CITY OF ALBUQUERQUE

May 25, 2018

RE: **McDonalds – Menaul and San Pedro**
5900 Menaul Blvd NE
Site Plan for Building Permit
(Non-stamped) Plan Date: 5/16/18 (File: H18D070)

Based upon the information provided in your submittal received 6/13/17, the Grading and Drainage Plan cannot be approved until the following are addressed:

Drawing file: ESC / C3.0 EROSION CONTROL PLAN.pdf

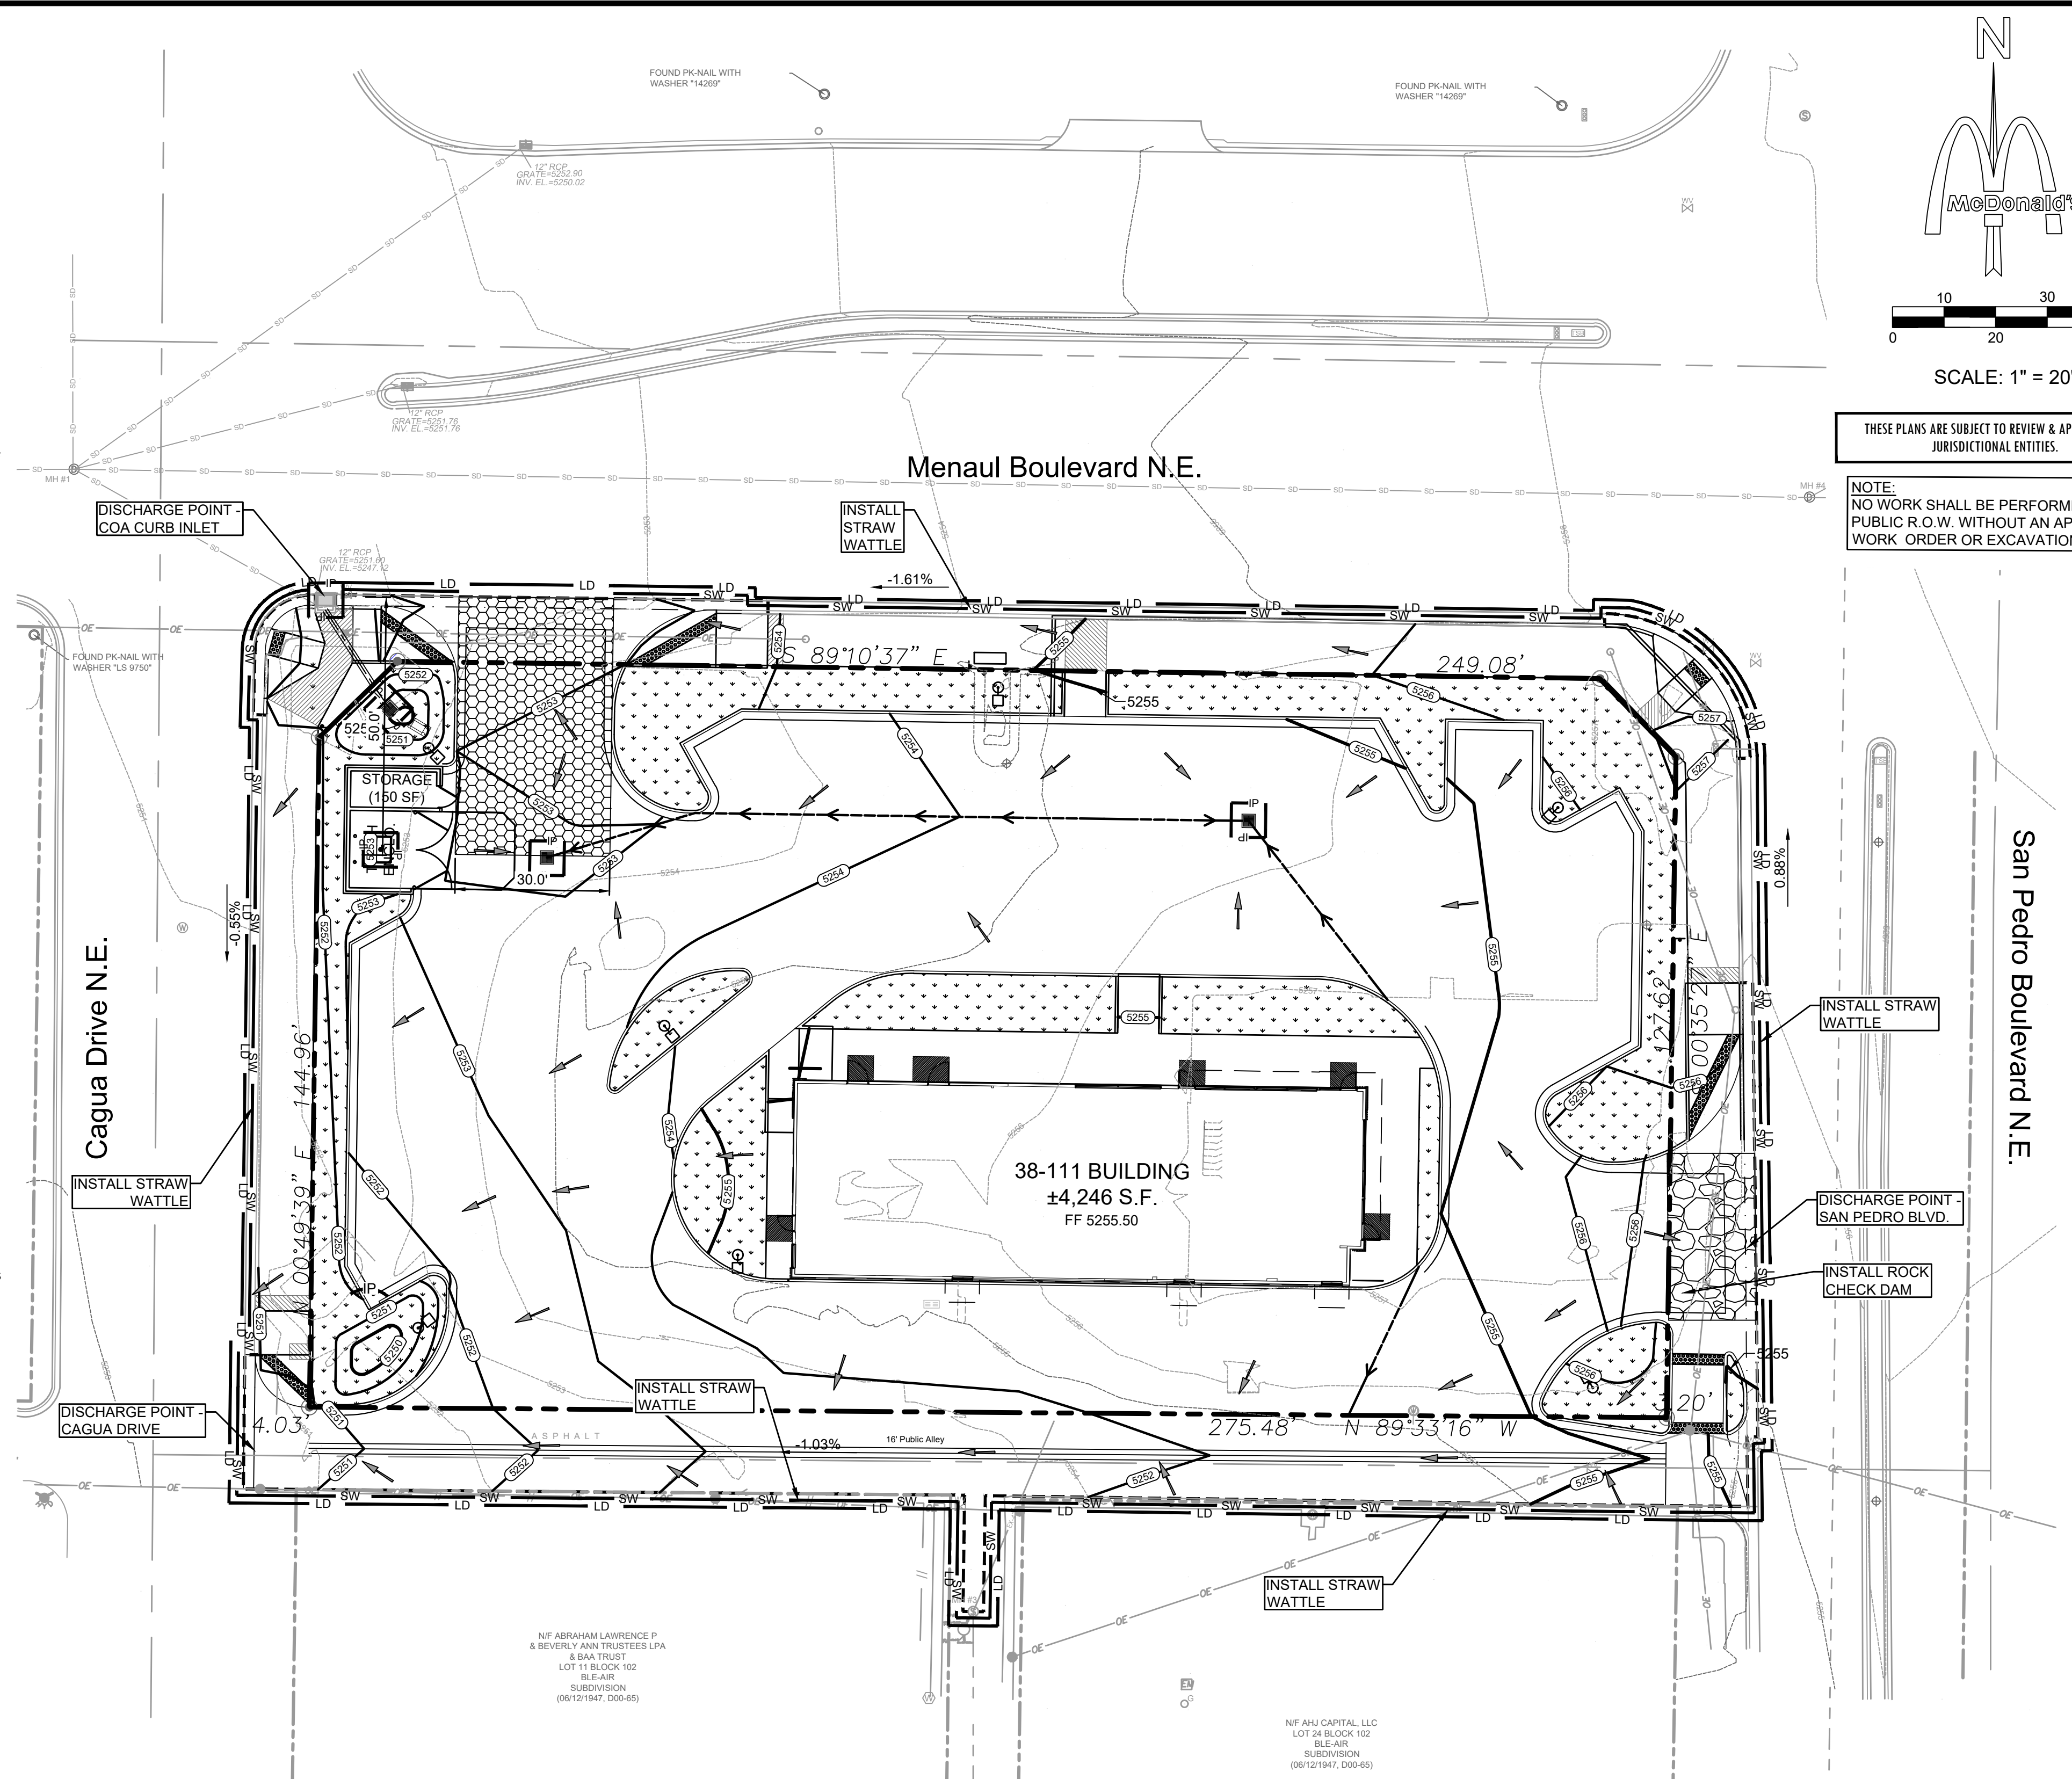
8. Waterblocks, 12" high from top of pavement on the drivepad to bottom of gutter along the road, need to be incorporated at the San Pedro entrance.
9. This work will require an Erosion and Sediment Control Plan submitted to the storm water quality engineer (Curtis Cherne, PE, ccherne@cabq.gov) before Building Permit Approval.
